Your Ref: OWPC18189
Our Ref: AB/4/18/PL 16-01-2018
Please ask for:
Ross Leal

Demolition of 4 No. existing bungalows & erection of 5 No. 2 bedroom dwellings with associated parking & landscape.

1-7 Canada Road Arundel

Thank you for your internet representation made on 10th May 2018 which has been recorded as **'an objection'** with the comments as follows:

Site Plan 1:200

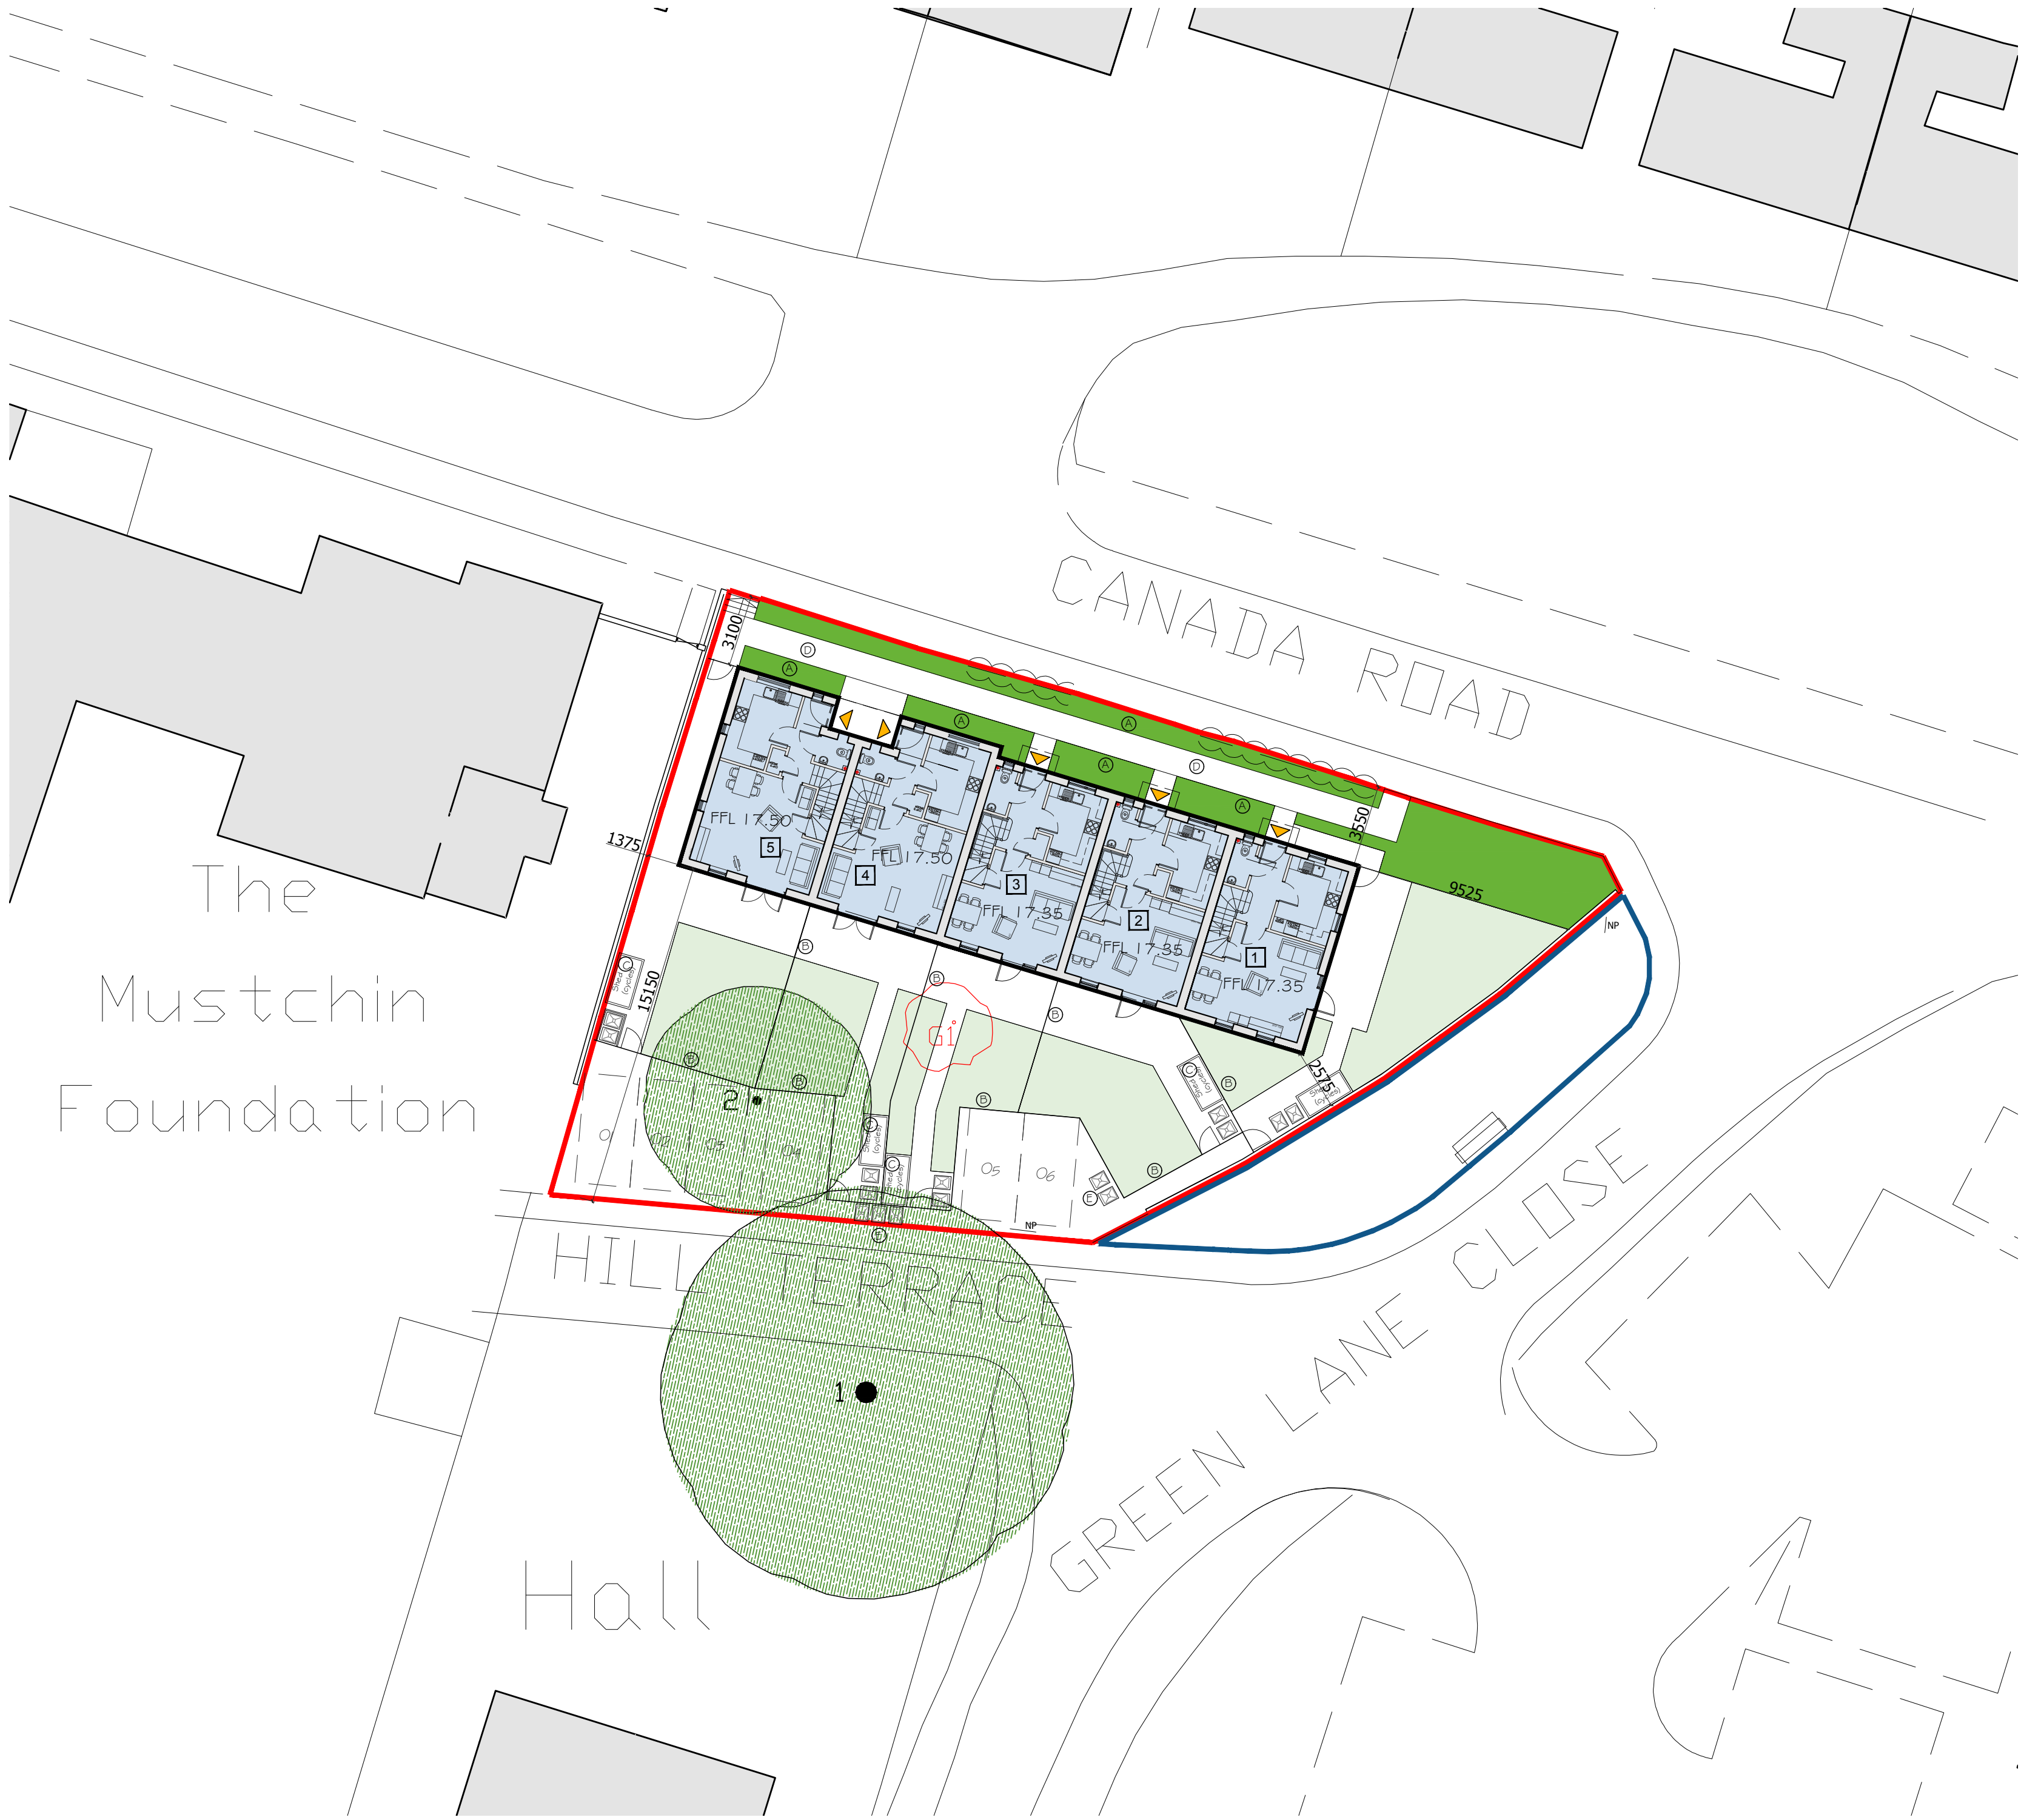
Living in close proximity to the proposed site I am acutely aware of the lack of parking in the area. There are times when I return home from work and am unable to park near to my home. Adding more houses without providing ample off road parking options that do not remove current on road parking options is simply not sustainable and will cause significant issues for existing residents but also those who move to the area. Canada road is used as a rat run from the A27 this makes it particularly dangerous when more strain is placed on this already over crowded area. Affordable housing is needed however this site is simply squeezing a handful of homes into an area which simply cannot sustain it. Surely there are alternative larger more suitable sites which would provide more homes without being as detrimental to existing residents. This is already a heavily populated area in comparison to other areas of Arundel hence the issues faced.
